City of Albuquerque

RE: DRAINAGE PLAN FOR A WAREHOUSE - TRACT 15-A1, BLOCK 3 OF MAYO & ROSS
ADDITION (J-14/D87) RECEIVED JANUARY 24, 1990

DRAINAGE PLAN

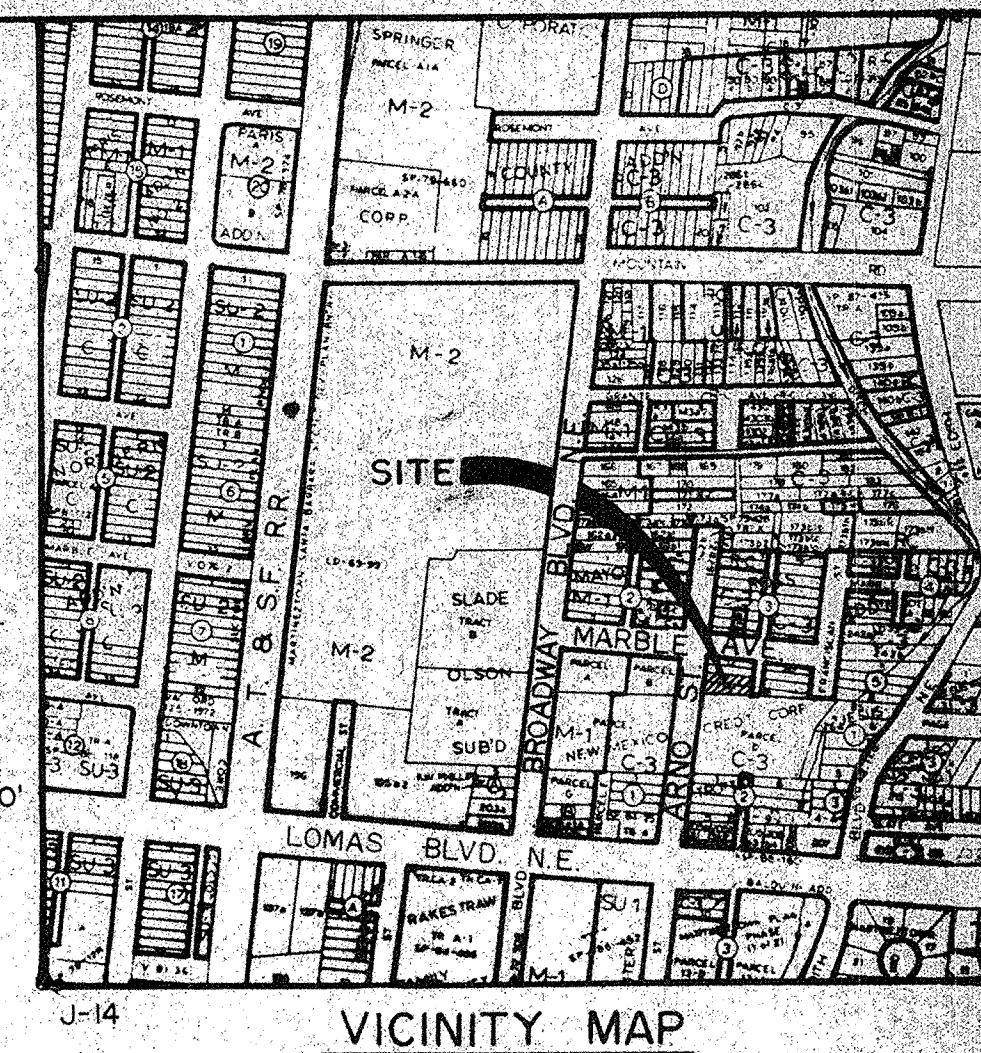
1. Site is encroached by an AH floodzone elevation of 4,954, therefore, finish floor will need to be set at 4,955.0. Finish floor elevation shown is adequate.
2. Engineer's Certification will be required prior to Certificate of Occupancy release.
3. Evaluation on the plan drawing that the site is within an infill area. The increase of runoff is minor compared to the basin.
4. Approval of vacation of the alley will trigger the release of the building permit.
